CITY OF ALBUQUERQUE

January 6, 2015

**Re: Sandia Prep School Running Track Reconstruction
Drainage Plan with Engineer's Stamp Dated 12-23-14
(E16D012)**

D:\SEC\PROJECTS\114653 Sandia Preparatory School\ENGINEERING\GDD\PLANSET\4 DRAINAGE PLAN.dwg Dec 02, 2014 10:47am Saved By: jmaesam

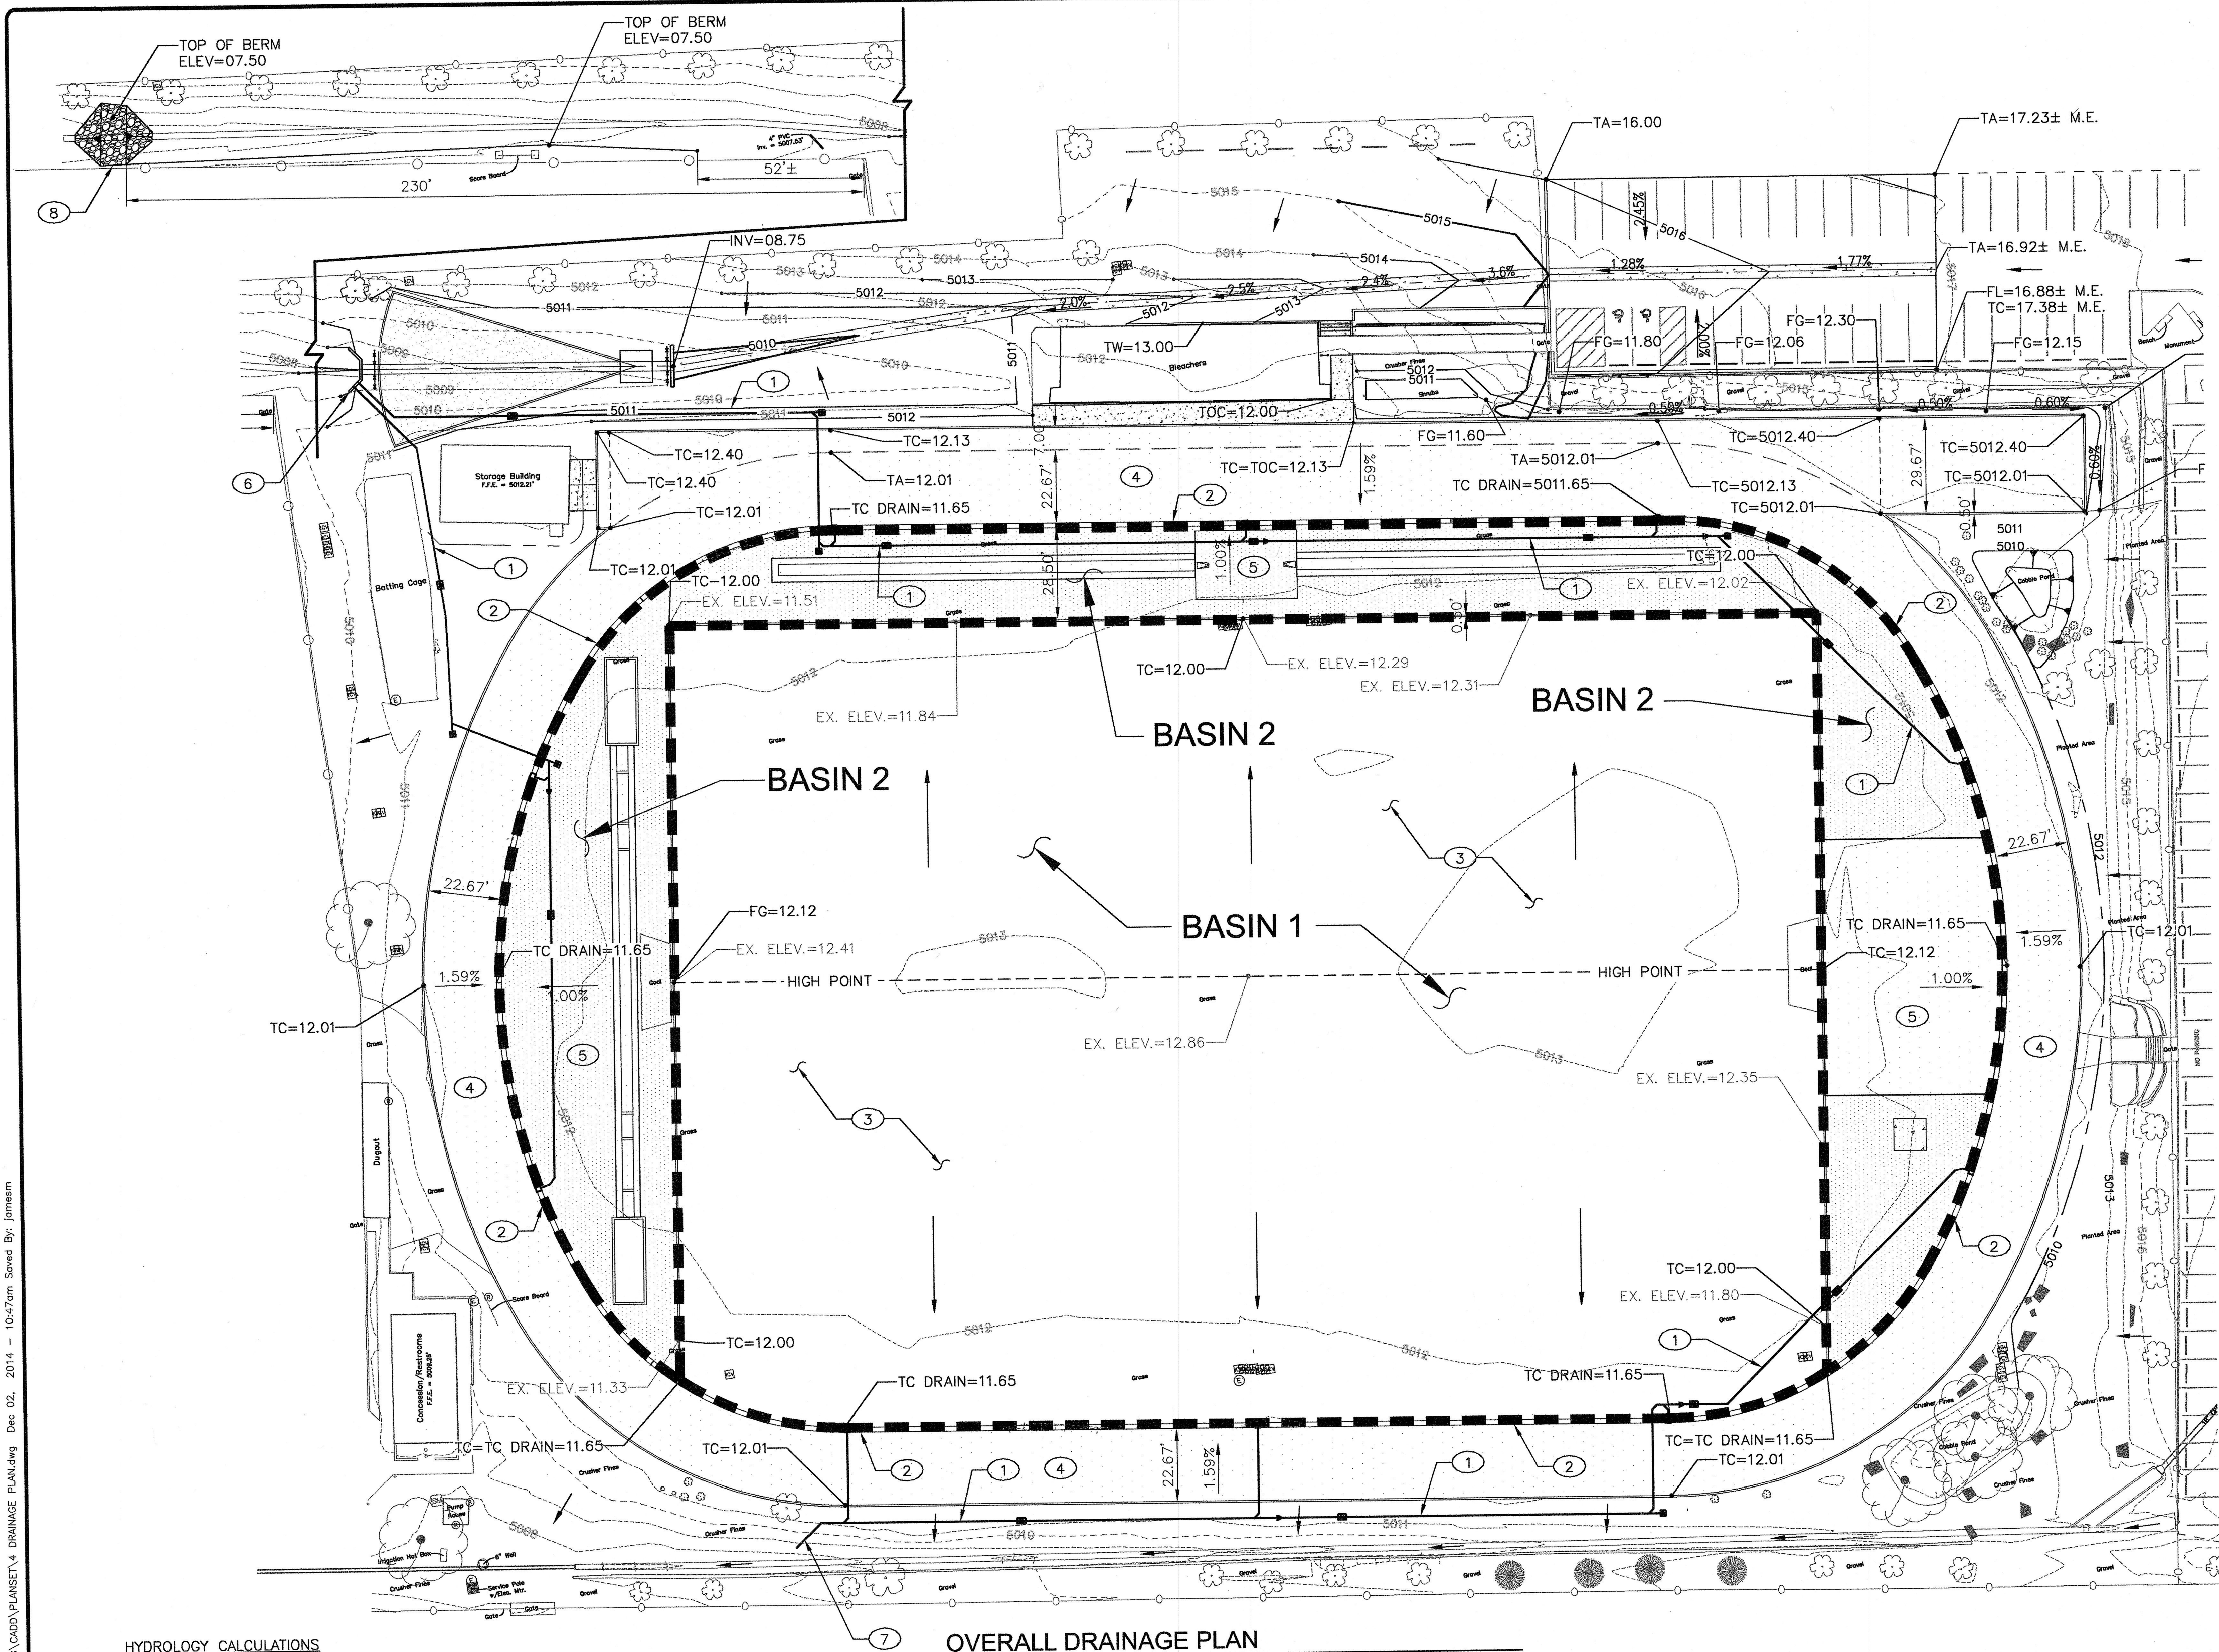
1. The 7.48 cfs is low for the northern swale. Currently, the calculations only account for the north parking lot and half the infield going into the existing swale. Although the plan shows the track itself draining to the infield, that area is not included in the flow for the infield system. The areas directly surrounding the track are not included in the flow for the swale. Although the berm is located 230 feet alongside the baseball field area, no flows are shown contributing toward swale before the proposed berm. Include a basin map and calculations that show flows from all these areas, not just the infield.

2. The proposed berm is blocking an existing swale. That was done to provide retention for the First Flush requirements. However, nothing has been provided to show once the flow tops the berm, the flow will still be contained in the remaining volume of the drainage swale as requested in the previous letter. Not enough contour information is provided on the south side of the berm to determine what will happen with the flow there. Will there be erosion of the baseball field?
